Date: 23 January 2018
PINS Ref: EN010082

EN010082 – THE TEES COMBINED CYCLE POWER PLANT ('CCPP') – SITE OF THE FORMER TEESIDE POWER STATION, GREYSTONE ROAD, GRANGETOWN, TEESIDE, TS6 8JF

THE PLANNING ACT 2008 (AS AMENDED) – SECTION 51 'ADVICE FOR POTENTIAL APPLICANTS AND OTHERS'

Title APPLICATION DOCUMENT REFERENCE No. 4.5  
 INDICATIVE GENERATING STATION PLAN SHEET 3 of 3  
 SCALE 1:2500

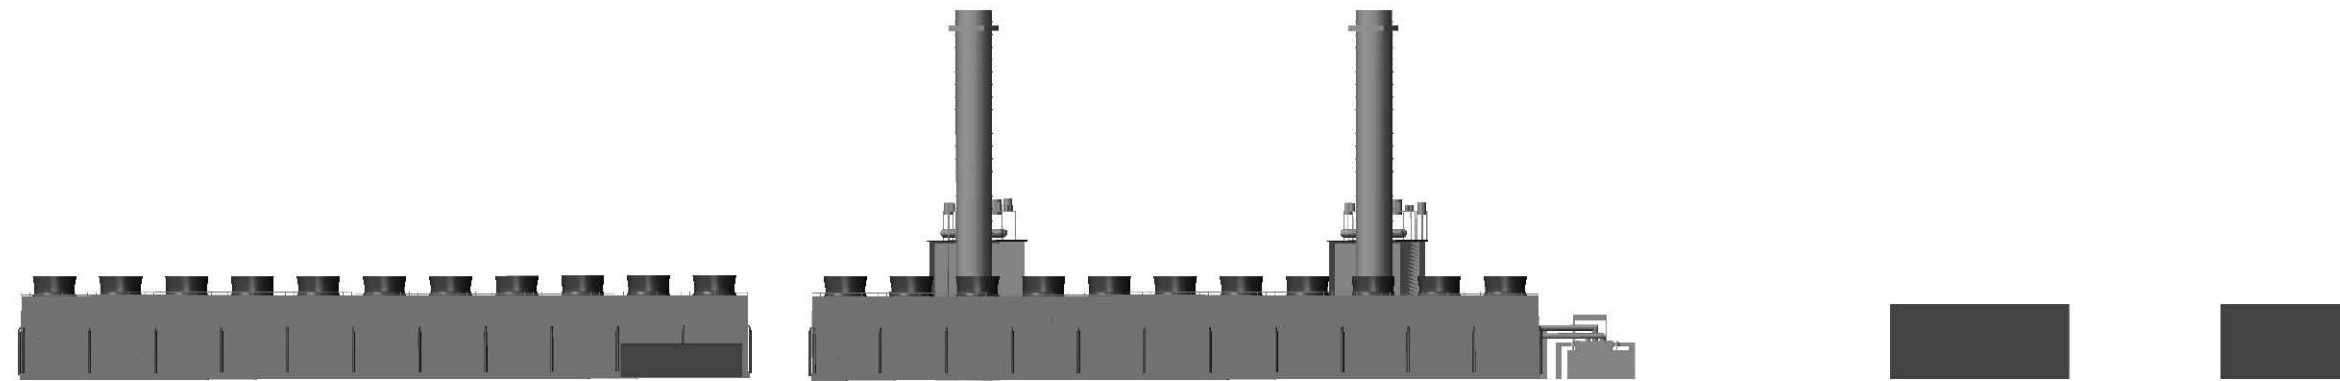
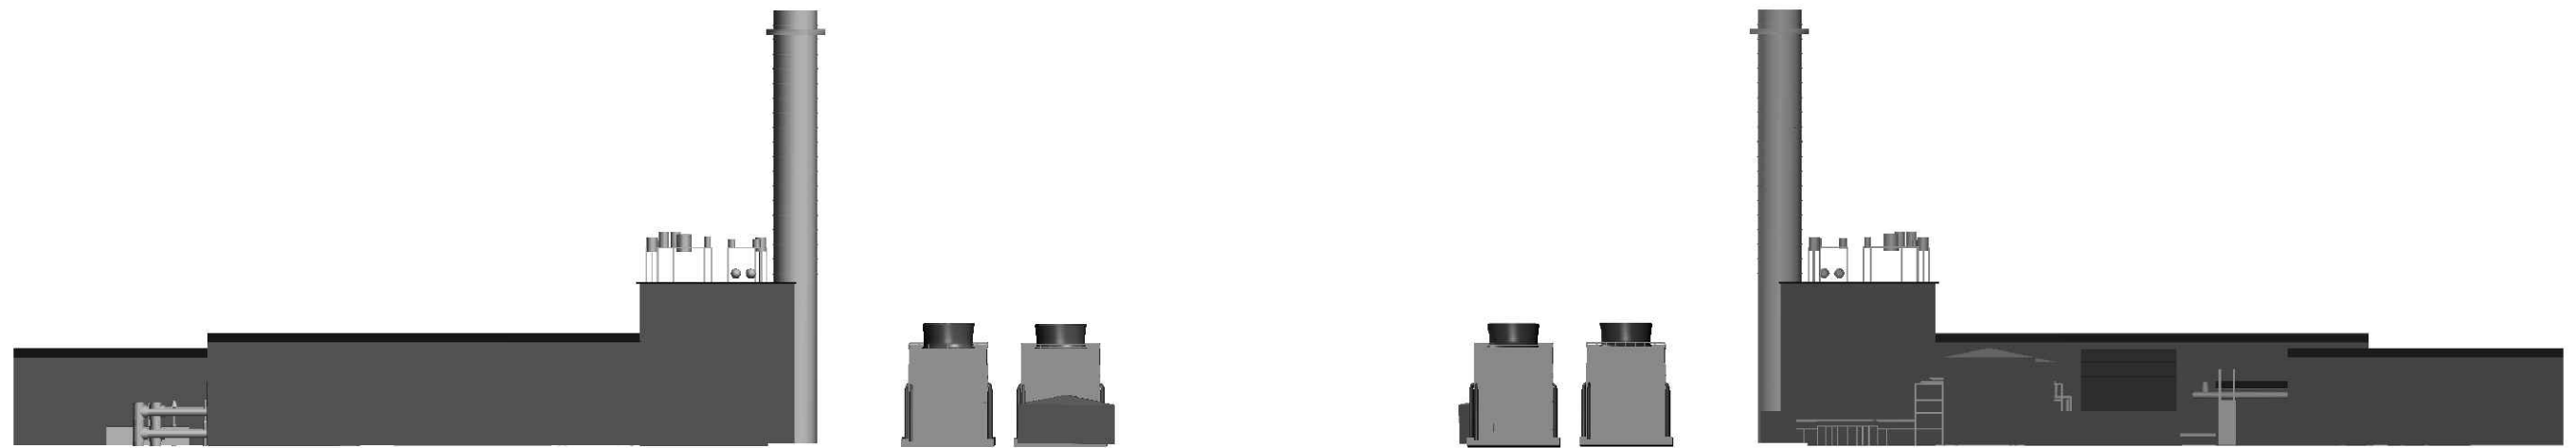
Works Plan (Application Document 4.5) Sheet 3: a scale bar has been added. Three hard copies of the updated plan are enclosed at **Annex 2** to this letter. Two electronic copies are also enclosed.
